WEST SUSSEX COUNTY COUNCIL CONSULTATION

TO:	Arun District Council FAO: Obafemi Okusipe
FROM:	WSCC - Highways Authority
DATE:	3 March 2022
LOCATION:	4 The Pantiles, Ferringham Lane, Ferring, BN12 5NE
SUBJECT:	FG/22/22/PL Change of use of top two floors from treatment rooms to 1 No 1 bed flat and 1 No 2 bed flat. This application is in CIL Zone 4 (Zero Rated) as flats.
DATE OF SITE VISIT:	n/a
RECOMMENDATION:	Advice
S106 CONTRIBUTION TOTAL:	n/a

SITE PLAN 1:500 @ A1

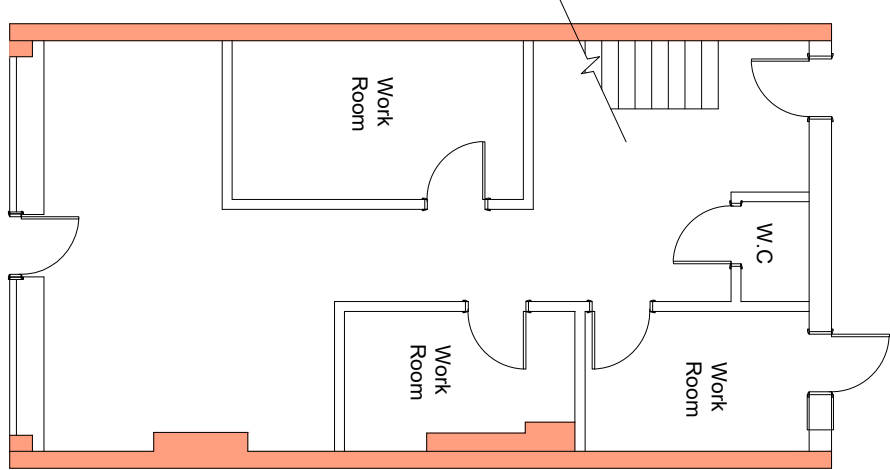
It does not appear that any off-street parking provision is provided for the proposed flats. Using the Arun DC Supplementary Planning Document for Parking Ferring is within parking behaviour zone 2. Therefore, each dwelling would be anticipated to generate the parking demand for 2 spaces per flat.

When assessing parking consideration needs to be given to the existing use. The existing 4 treatment rooms spread across the two upper floors would have generated its own parking demand which would likely have been similar to the proposed use. The existing parking would likely have made use of what appears to be some communal parking within the site frontage, but outside the red edge of this application. It is not clear if residents of the flats will be able to make use of this provision.

The Local Planning Authority may wish to clarify with the applicant where it is anticipated any parking demand will be accommodated. However, the highway network immediately adjacent to the site is maintained privately. It would therefore not be anticipated that any parking implications, if any, would impact upon the local highway network for which West Sussex County Council is responsible for.

The flats should be provided secure and covered cycle storage. This may not be possible given the constraints of the site. The Local Planning Authority should consider if securing such a provision would be achievable in this case.
